From: Anita Gardner
Sent: 26 July 2018 15:40
To: Planning.Responses
Subject: FW: LU/191/18/DOC

From: Colin Giddings
Sent: 25 July 2018 14:03
To: Anita Gardner
Subject: LU/191/18/DOC

Condition 5 –CMP

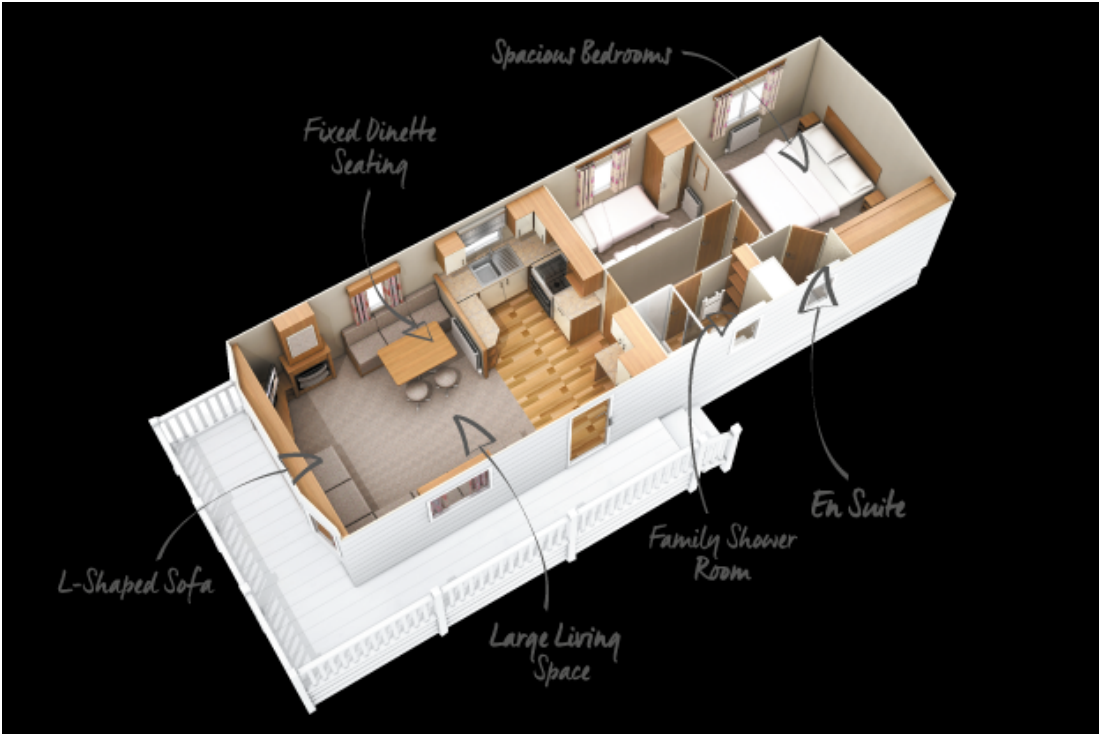
There is mention of a plan for the proposed wooden structure but I have not had sight of this. The site will need to comply with spacing and safety standards when in operation. Without details of the proposed structure I cannot comment further.

The wooden shed 2400x 1800 as per drawings submitted. Manufactured by Skinners or similar by many manufacturers.
